July 28, 2009

RE: **72 Walnut Street, 2 unit residence**

Application ID: 2006-0230

On July 28, 2009, the Portland Planning Authority approved a minor site plan for a duplex residence at 72 Walnut Street as proposed by Shopov Properties LLC. The approval is given on the basis of the application, plans, reports and other information submitted by the applicant, and the findings and recommendations contained in the Planning Authority staff review comments (listed below and attached) which found that the proposals meet Zoning requirements, Land Use Ordinance 14-526 (a) 1- 11 and 15, R-6 Infill Development Design Principles and Standards, and the City's Technical Standards in respect of traffic, storm water management and erosion control.

Date: 04.21.09  
Scale: 1" = 10'  
Drawn: MLC  
Project: SHOPOV 05-093  
Sheet: SITE & UTILITY PLAN  
GRADING & DRAINAGE PLAN  
SP-1

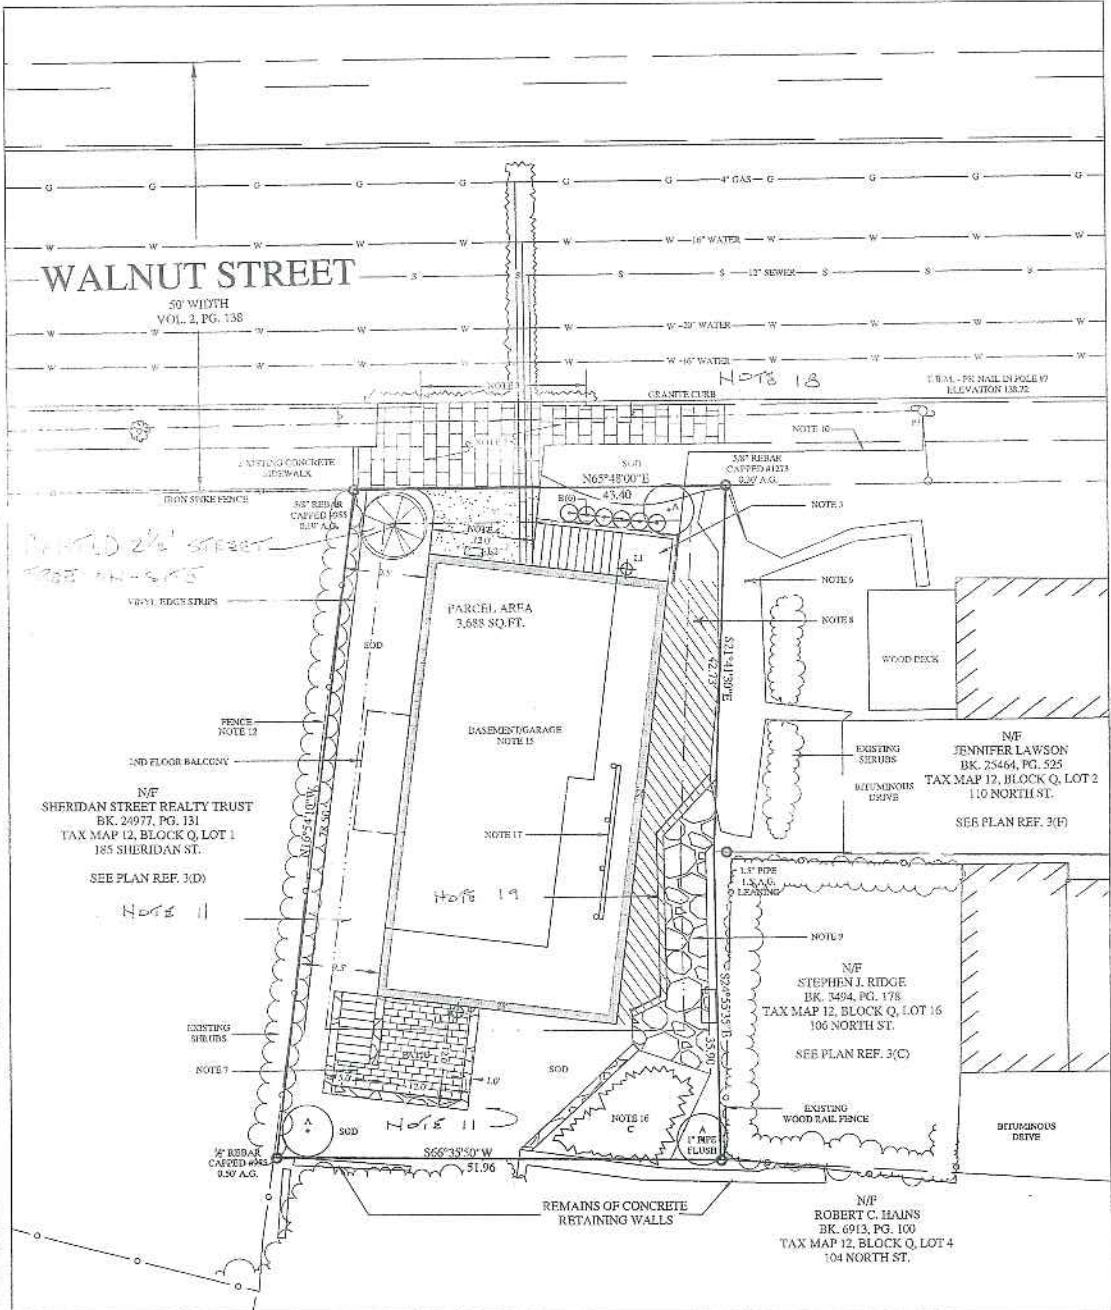
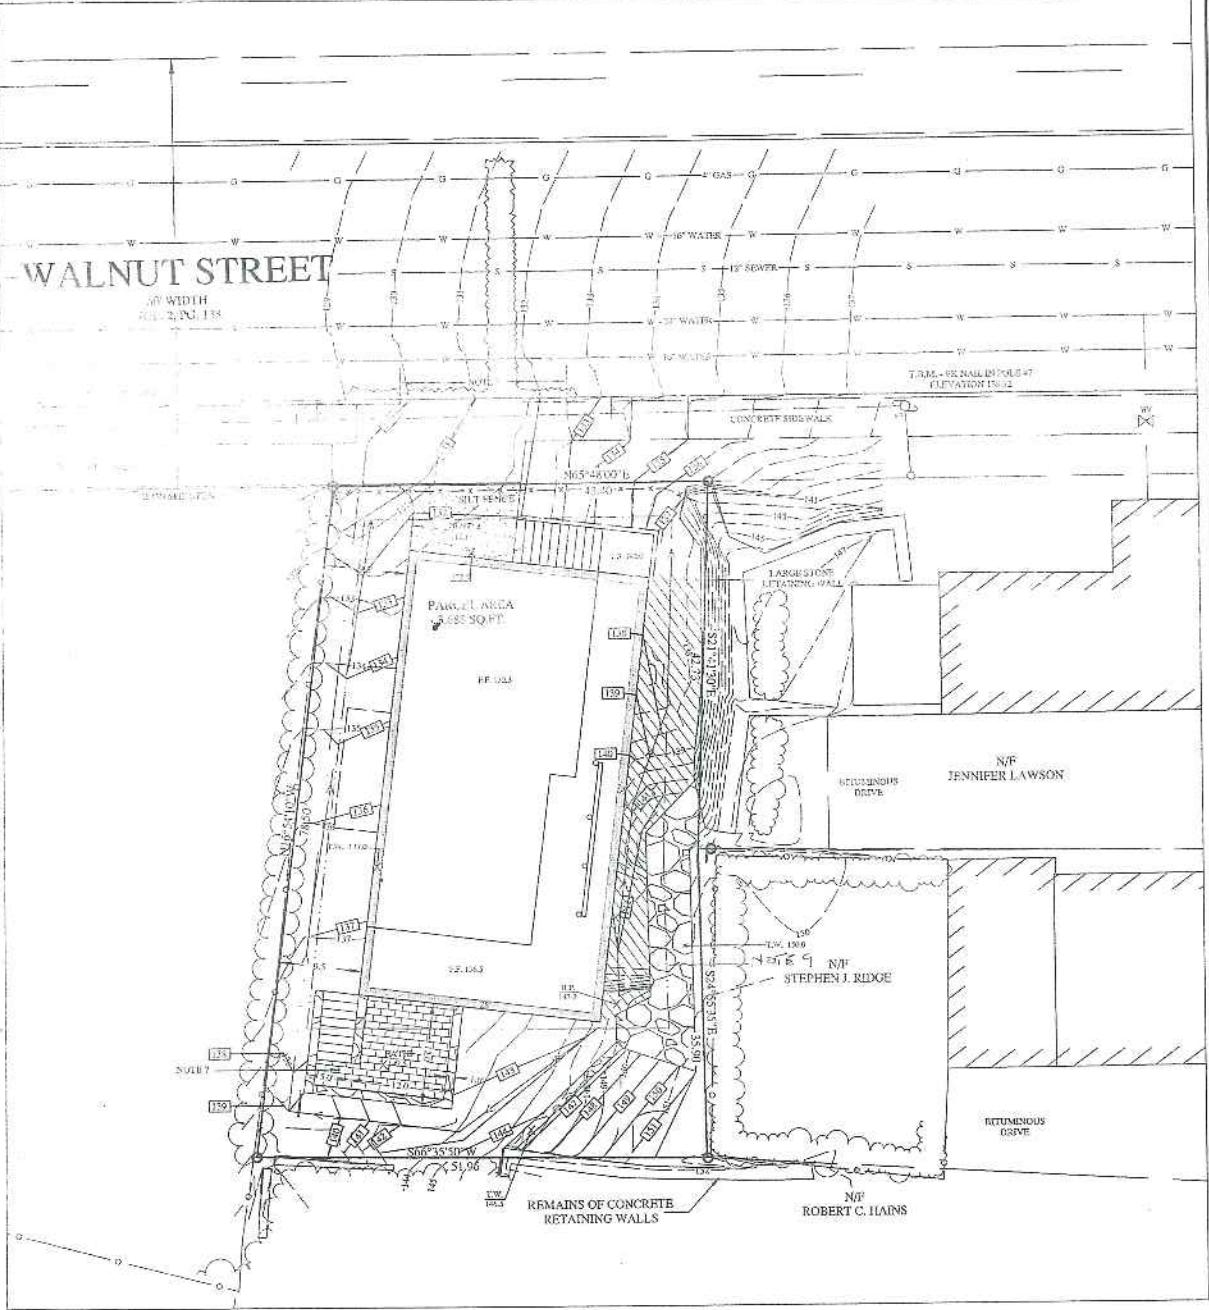
- v. That the applicant submit, for review and approval by the Planning Authority and the City Arborist prior to the issuance of a building permit, a revised Landscape Plan that addresses the comments of the City Arborist (Jeff Tarling) as set out in an e-mail dated June 24, 2009.

No parking is shown to be on the exterior of the building to the right of the building. All approved parking is interior. It was my understanding that trees or other landscaping would be located in that area to prevent future parking. There should be a condition on the final plans that if parking is found to be located on the side of the building after construction that a site plan amendment be filed with the removal of the parking until or if approved by staff.

a) Street-trees - the proposed project triggers the planting of 4 street-trees (2-trees per unit) the proposed planting along Walnut Street covers 2 of the 4 trees needed. We would ask that the project either contribute funds to cover planting two trees along Walnut Street or general area or actual plant the two trees. Either way we would work with the project team to determine the location for the two additional trees. The two trees along Walnut Street are shown as 1 crabapple, we would suggest 'Donald Wyman' or similar size crabapple. And the the second tree on the rights side should be an upright shade or ornamental tree, we would suggest either a Ginkgo or columnar English Oak. There are a number of alternative species & cultivars and we would be willing to suggest or approve with the project team.

b) Landscaping - The landscape plan shows a bed of 'Bar Harbor' Juniper containing 20 pots, the plant size should be 5 gallon pot minimum size. Additional landscape plantings could be planted along the base of the existing retaining wall and along the fence line of the adjacent Portland Water District site to add some interest and provide some buffering from within the proposed project. This could be accomplished by planting 2 groups of 3-5 shrubs along the fence line & wall. Suggested species could be 'Miss Kim' or 'Korean' lilac, or Viburnum, 2.5' in height. These plantings would be similar to the typical foundation plantings that traditional duplex might have as a standard. I would be willing to review, recommend planting types & locations and would agree with the project team input of their locations along the property line.

FRONT ELEVATION

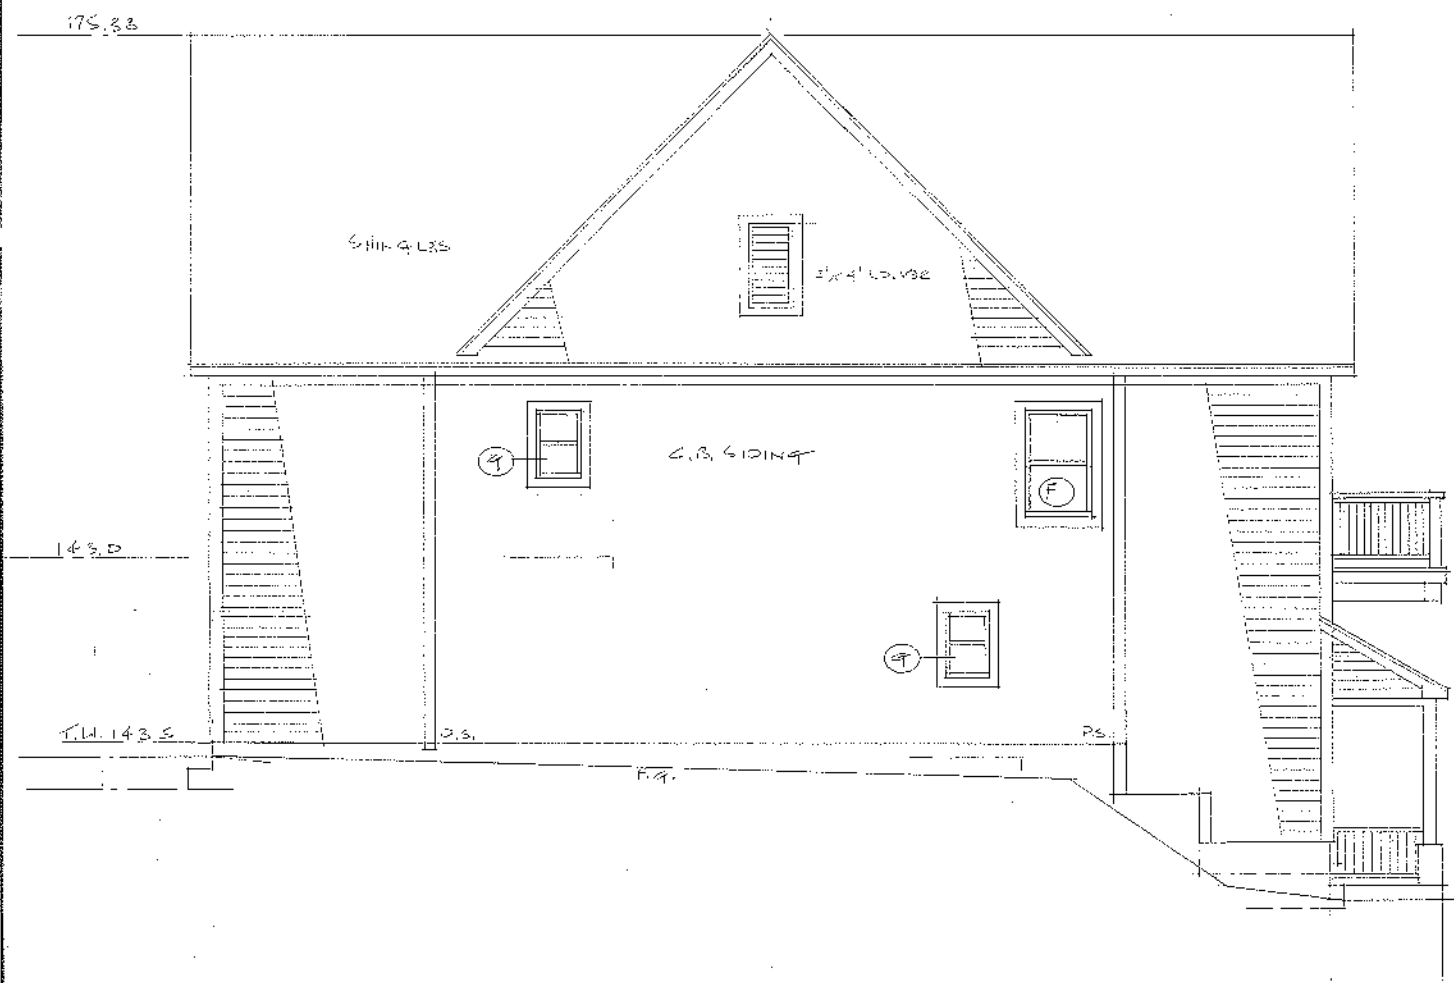
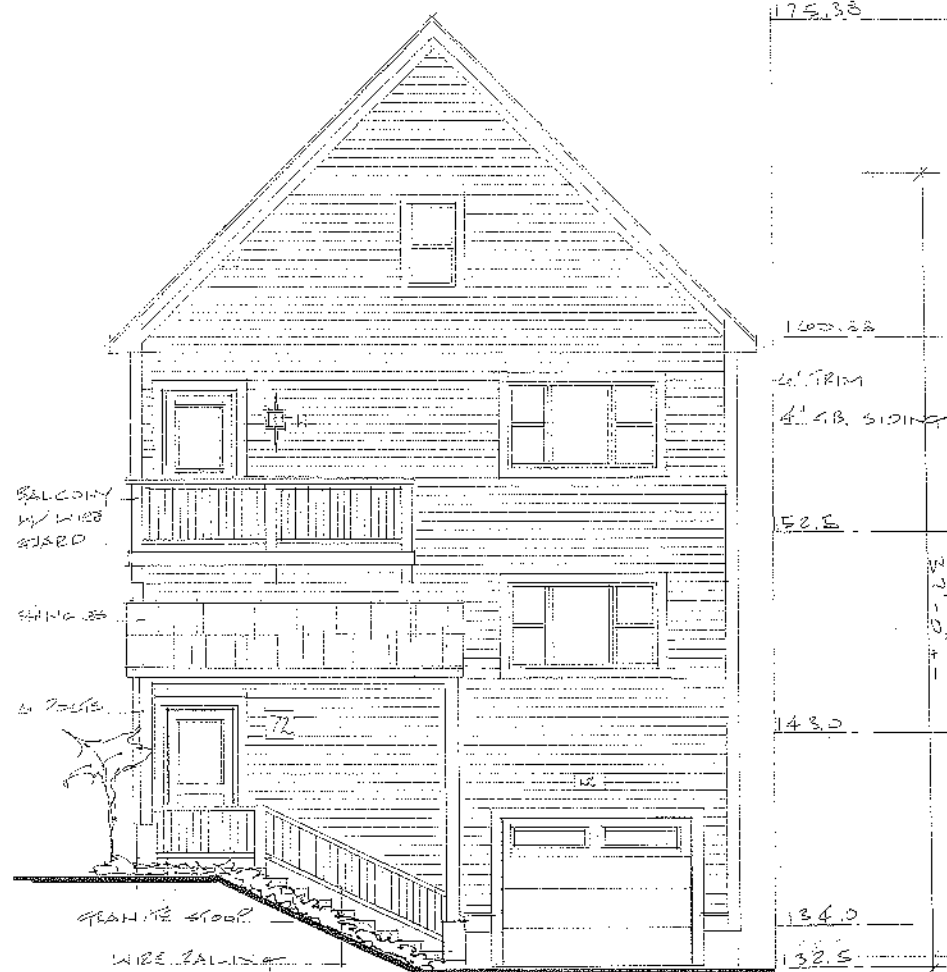
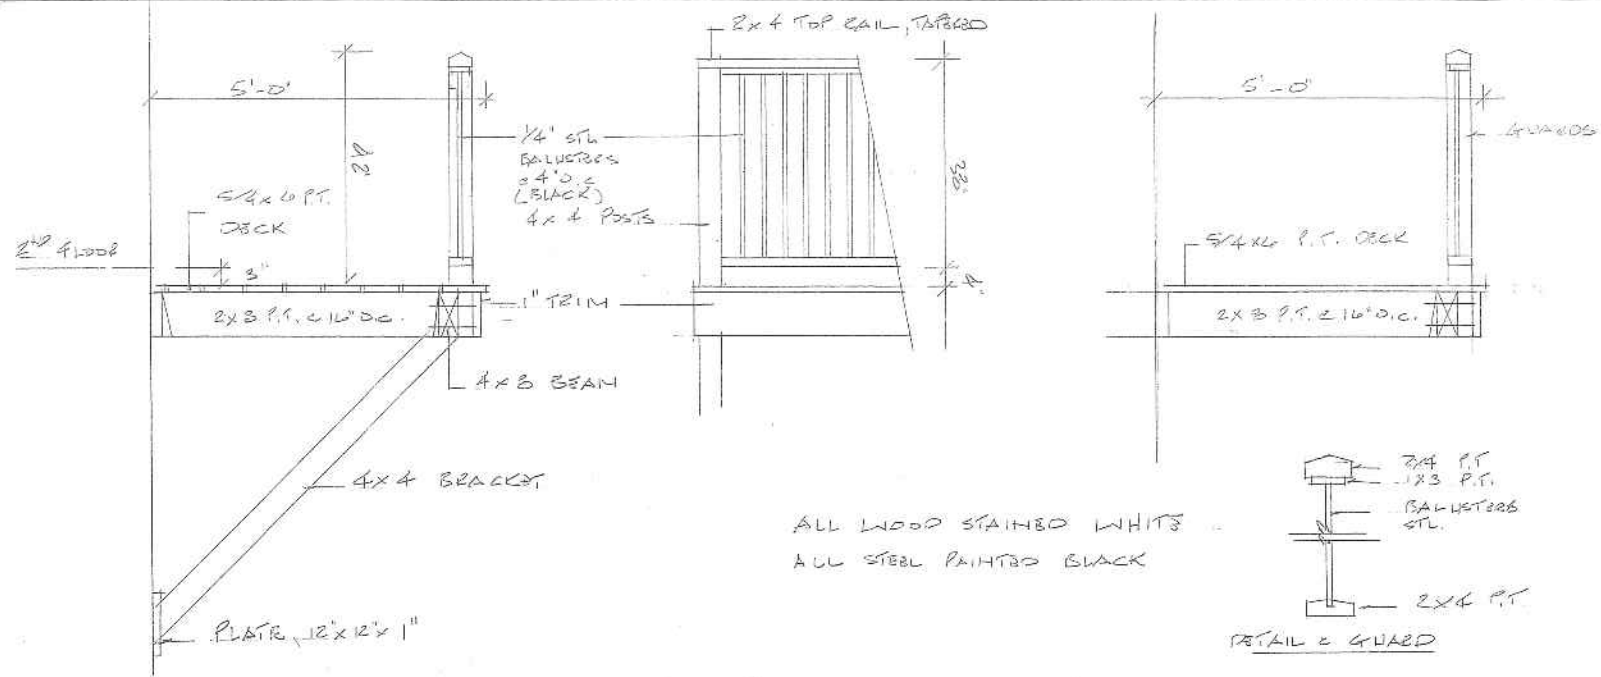
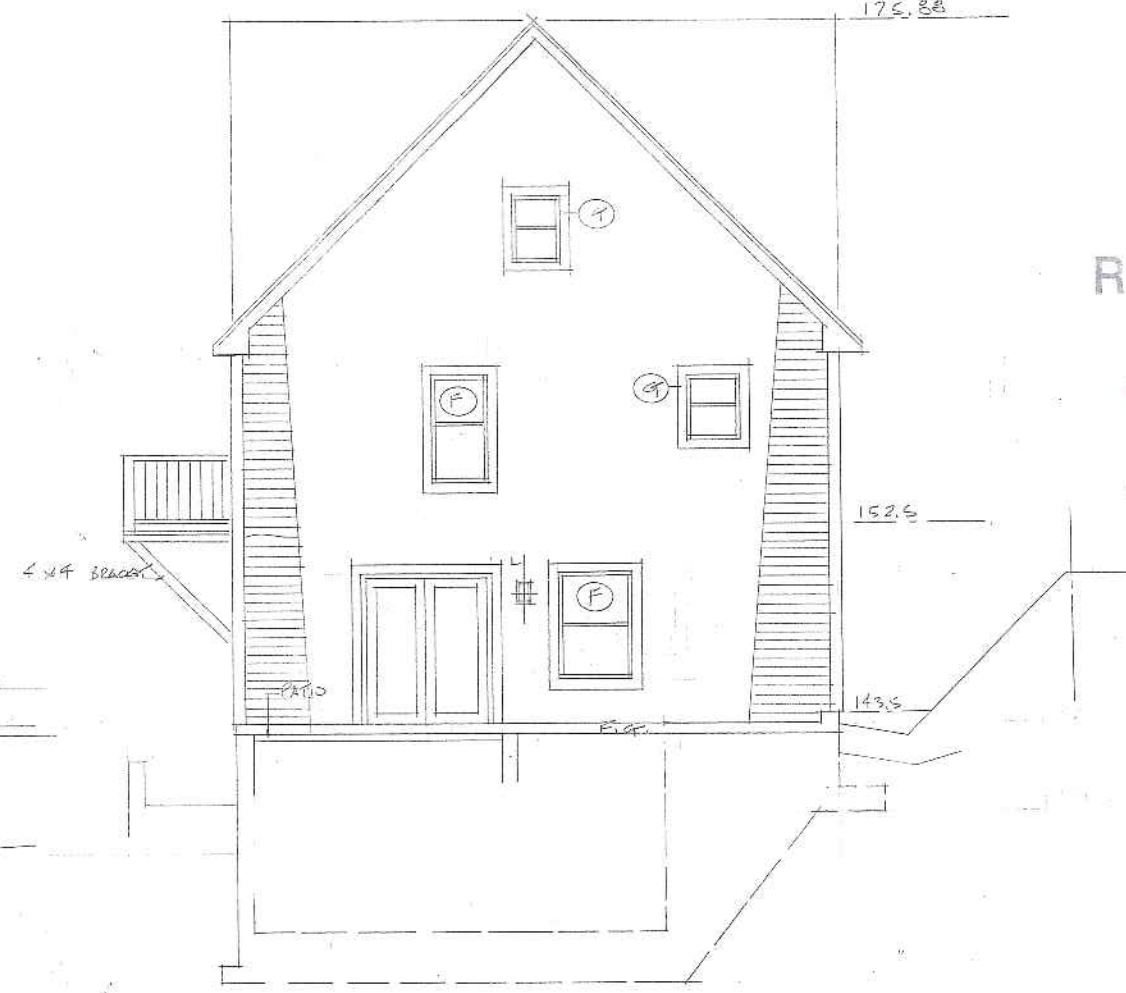
- i. That the applicant shall submit for review and approval prior to the issuance of a building permit, revised plans that correct the 1.25 foot discrepancy in scaling of the elevations; and

I have reviewed the most current plans received on 6/17/09 - There still is about 1.25' discrepancy in scaling the elevations. Certainly that is more accurate than before. The height limits are being met. The landscaping stairs to the patio are meeting the ordinance.

- *The revised building addresses most of the issues raised in relation to the earlier submissions. The main outstanding issue is the fenestration on the front elevation which does not meet Standards D-1, F-2, and G-4. As discussed, the two kitchen windows need to be revised and another window should be introduced over the porch, either to align with the main entrance door or centered on the porch roof.*
- *Thank you for the samples of materials, which are acceptable. Please specify on the plans (we do not need to see samples) the porch and balcony finishing details.*

The final plans (received June 12, 2009) provided the remaining few details, introduced another door over the porch, and revised the windows on the front elevation (similar to those on the other elevations; also balanced and stacked within the front elevation). The final plans also address Deb Andrews (HP) request that the doors on the front elevation have glazing bars and that the porch supports be reduced in scale.

Staff did not find any benefits associated with the alternative front elevation (submitted at the same time), so Plan A1 (dated 4.20.09 rev.6.7.09) is the basis for this final review. Staff considers that, with the revisions made by the applicant over the last few months, the proposals in the 6.7.09 Plan Set now meet the *Design Principles and Standards*.
